Demolition of existing garage & outbuildings. Alterations to external materials (including change from thatch to clay tiled roof and brick/stone to fibre cement weatherboarding and coloured render). Alterations to existing fenestration, including to 2 no. ground floor rear bay windows, and addition of first floor front dormer, enlarged balcony at first floor level at the rear. Replacement garages.

The Breakers 29 Tamarisk Way East Preston

Thank you for your internet representation made on 12th February 2020 which has been recorded as '**an objection**' with the comments as follows:

1:100 West Elevation

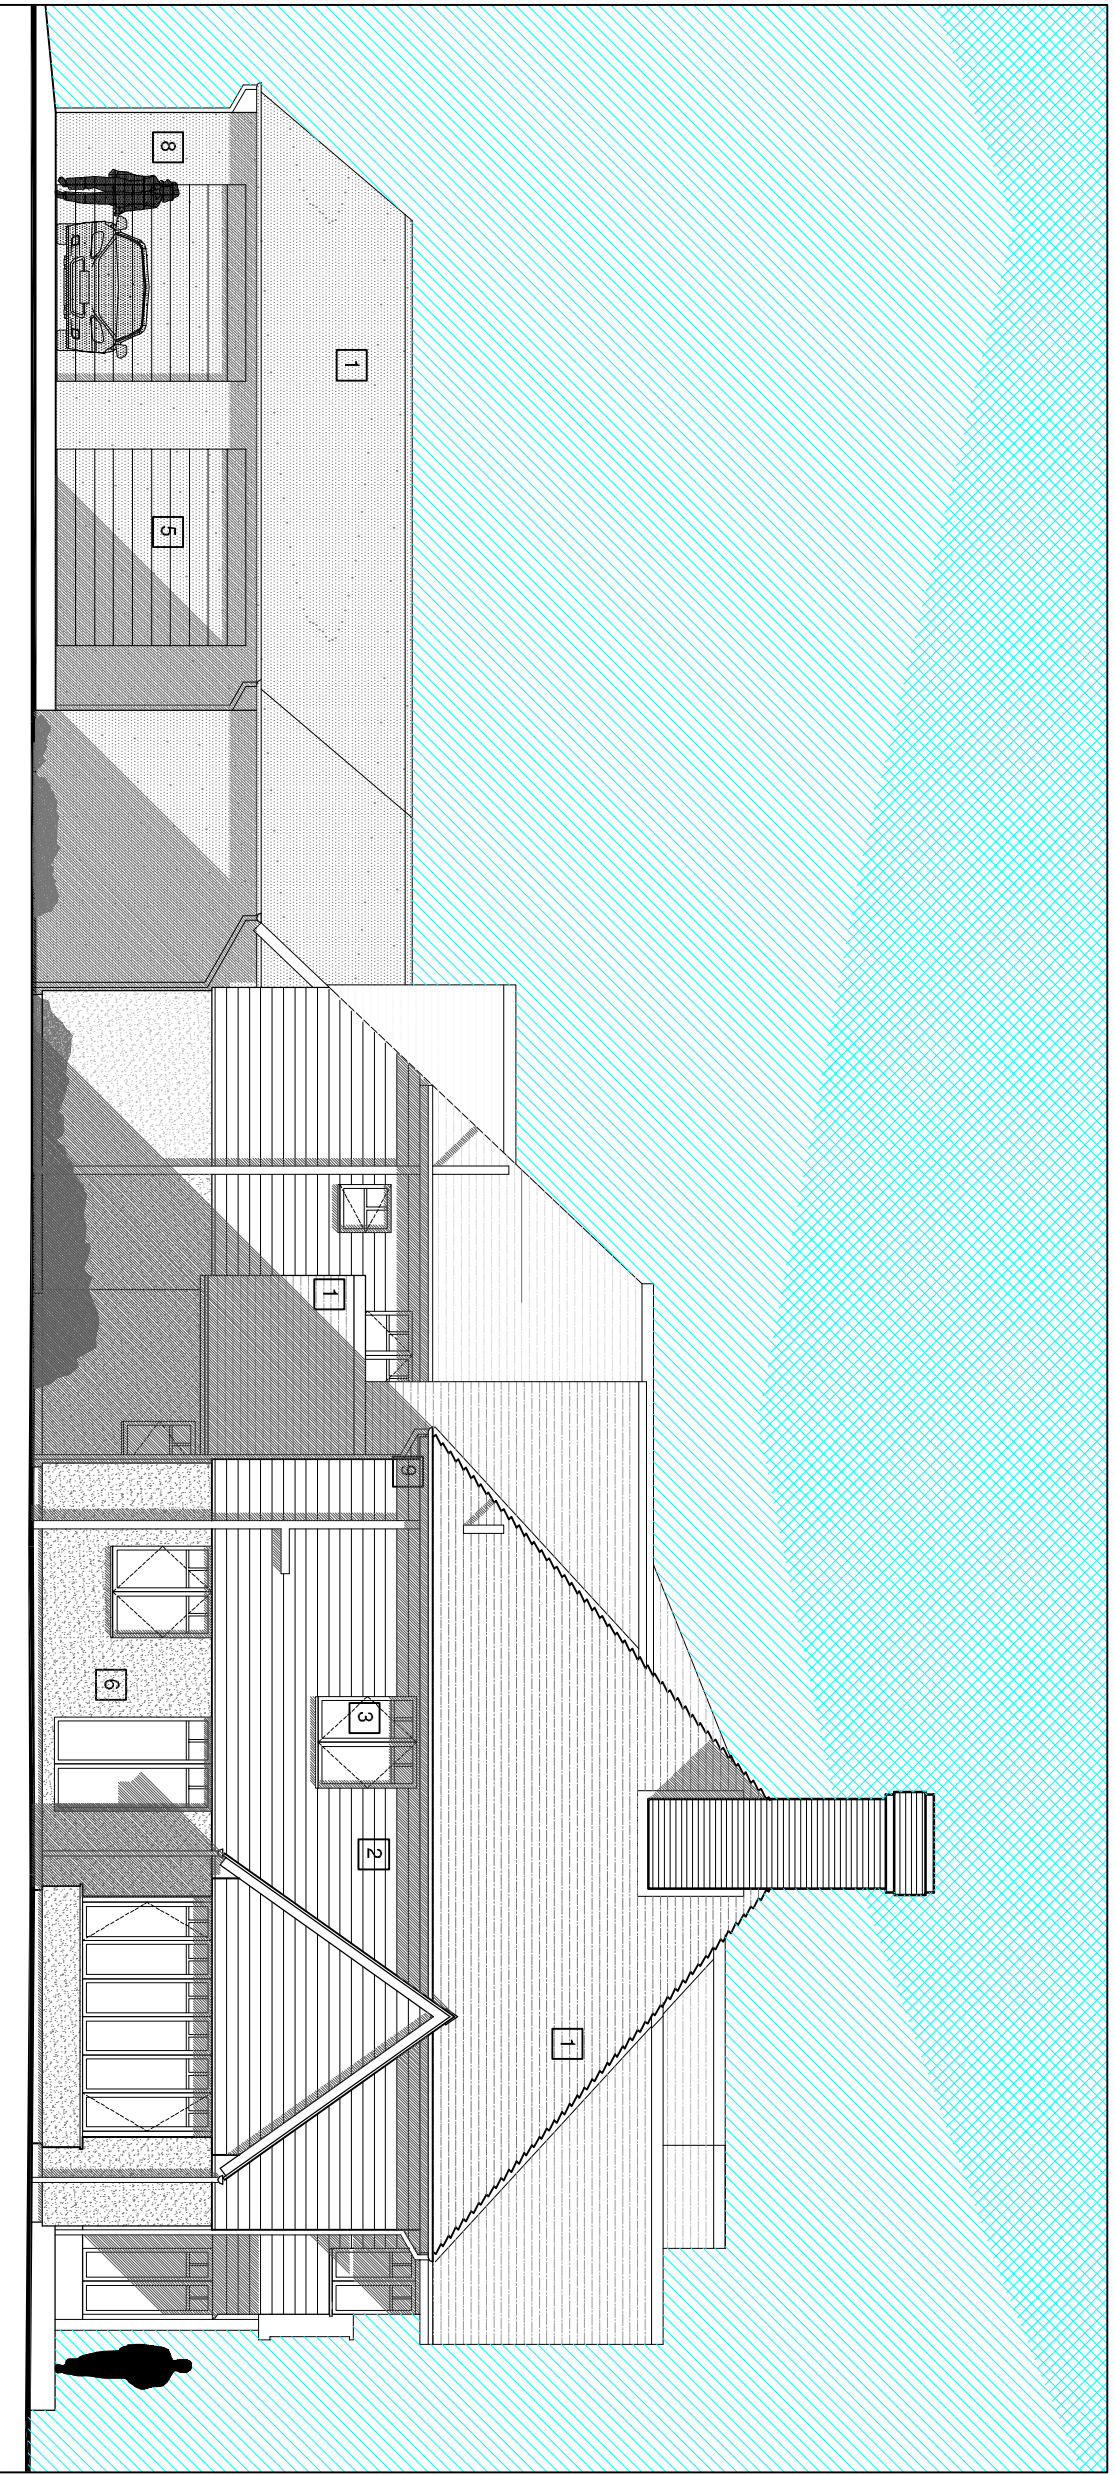
The applicant has stated that the proposals would be diametrically opposed to these objectives, by writing in the Planning Statement that his objective is to produce a house in the New England style, by replacing the thatched roof with tiles and adding fibrecement boards to the upper storey of the outer walls. The proposed 1.95 metre brick wall along the road would transform the setting of the house. The present render and stone wall is a valuable part of the setting that should be preserved.

The applicant wrongly asserts that a New England style house would reflect the design of neighbouring properties. The two neighbours to the west are in Arts and Crafts style; one neighbour to the east is nondescript while the other is Arts and Crafts. A New England style house would look out of place among the Arts and Crafts style houses that now create a harmonious and attractive group.
